THE VICTORIA HOTEL, MARKET PLACE, CLITHEROE, LANCASHIRE, BB7 2BZ

**Notifications under Circular 01/2001, Circular 08/2009 & GDPO 1995
VICTORIA HOTEL, MARKET PLACE, CLITHEROE, RIBBLE VALLEY
Application No 3/2012/0074**

DWG. DESCRIPTION
 Proposed Floor Plans

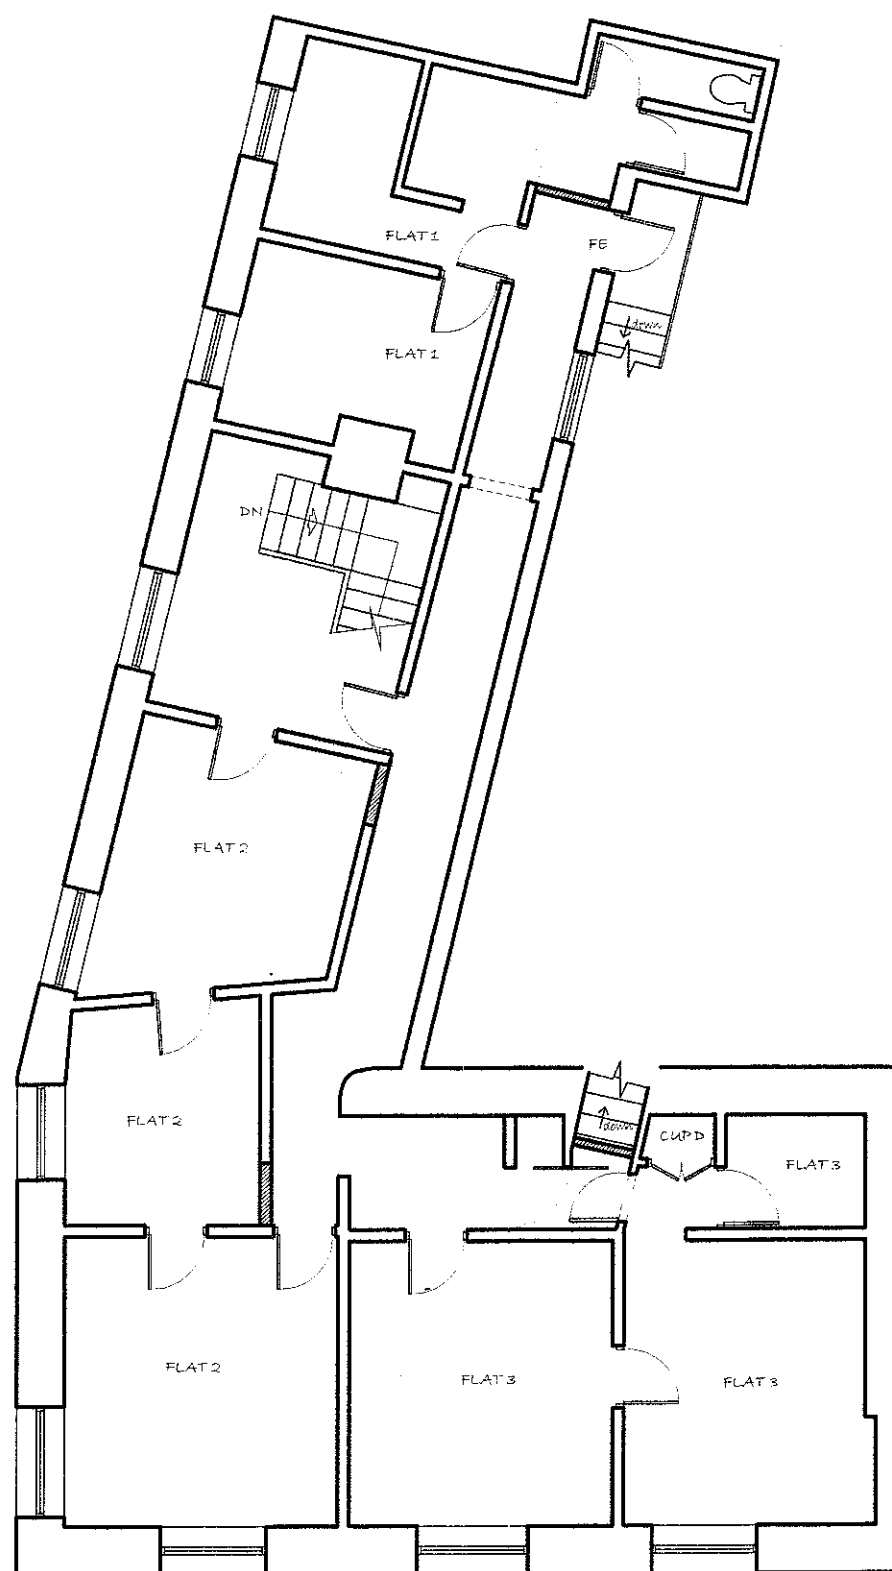
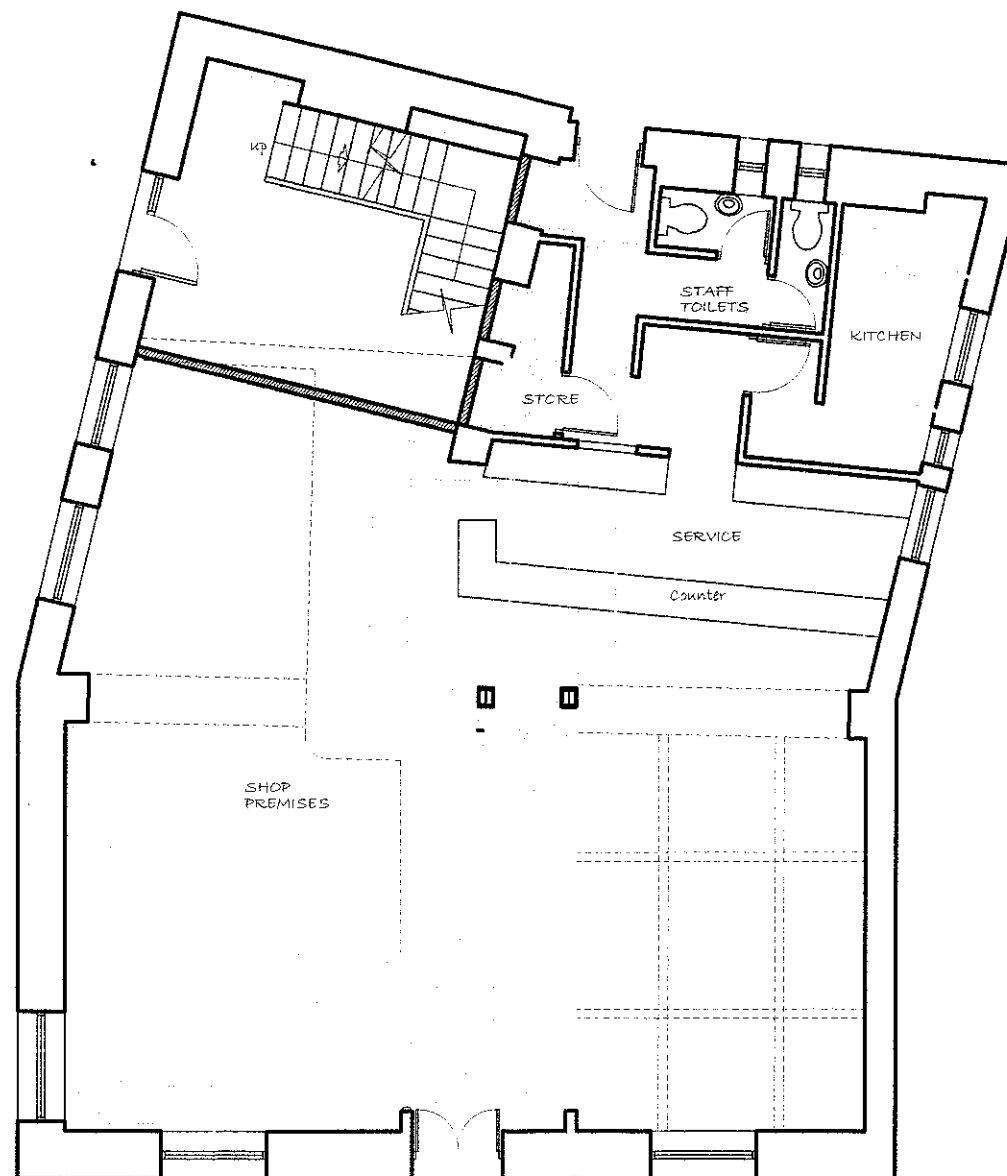
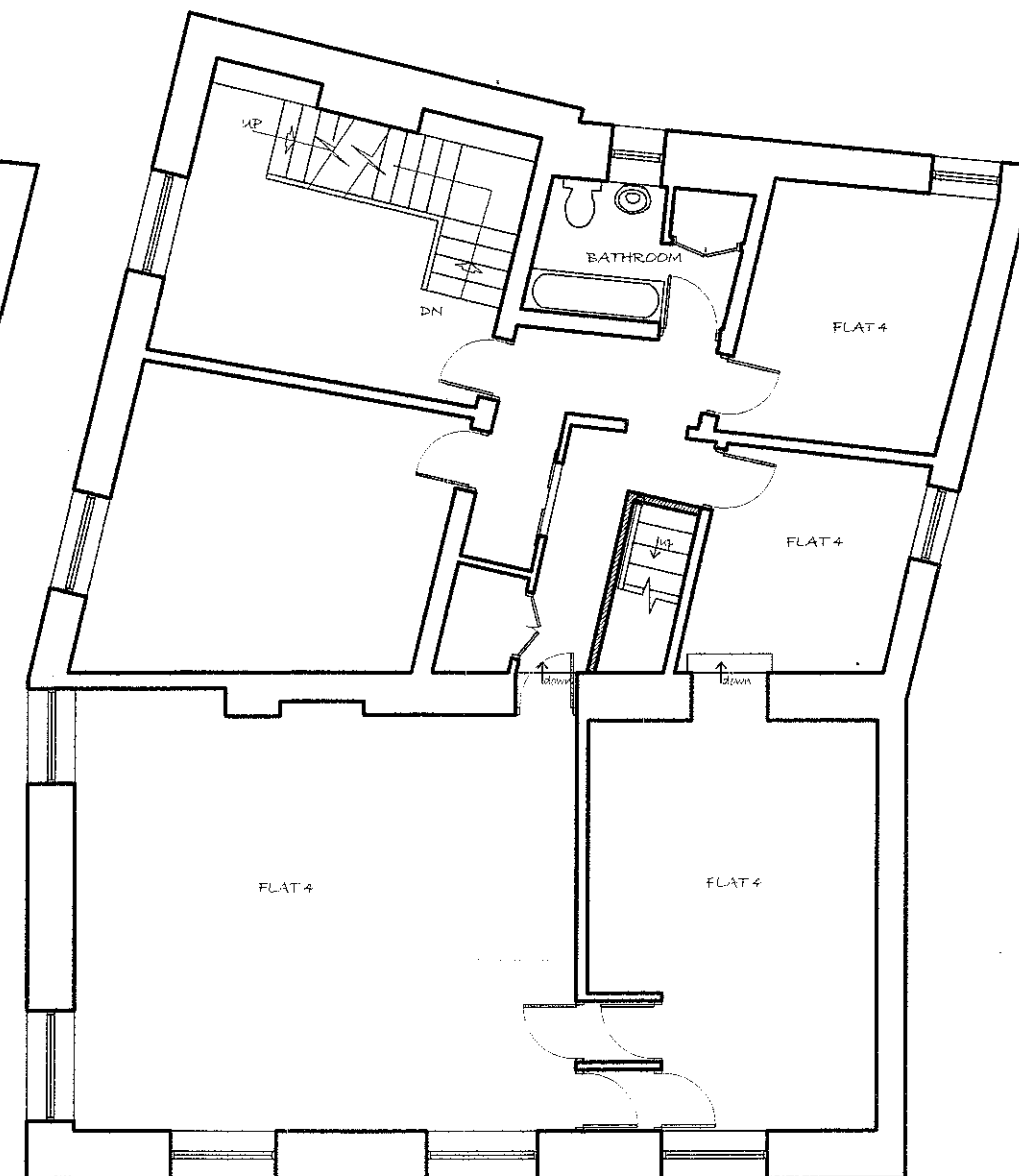
The listed building consent application proposes the removal of a staircase and the demolition of internal load bearing walls (however section drawings have not been provided in order to clearly define the extent of demolition proposed), therefore consultation with English Heritage is required in under Government Circular 01/01: Arrangements for Handling Heritage applications.

We draw your attention to the Historic Environment Planning Practice Guide (HEPPG, paragraph 182 states that staircases (whether decorated or plain, principal or secondary) are to form part of the significance of a heritage asset. Indeed they may be its most significant feature. Proposals to modify internal arrangements, including the insertion of new openings, will be subject to the same considerations of impact on significance as externally visible alterations.

Given that the supporting information submitted with the application makes no reference to the National Planning Policy Framework (NPPF) (March 2012) or the HEPPG and the lack of assessment of the significance of the staircase, internal photographs and sections drawings showing the extent of internal demolition

proposed, we are unable to assess the impact this would have on the significance of the listed building. Therefore, at present we are unable to support the listed building consent application and advise that further information is requested from the applicant to address this issue.
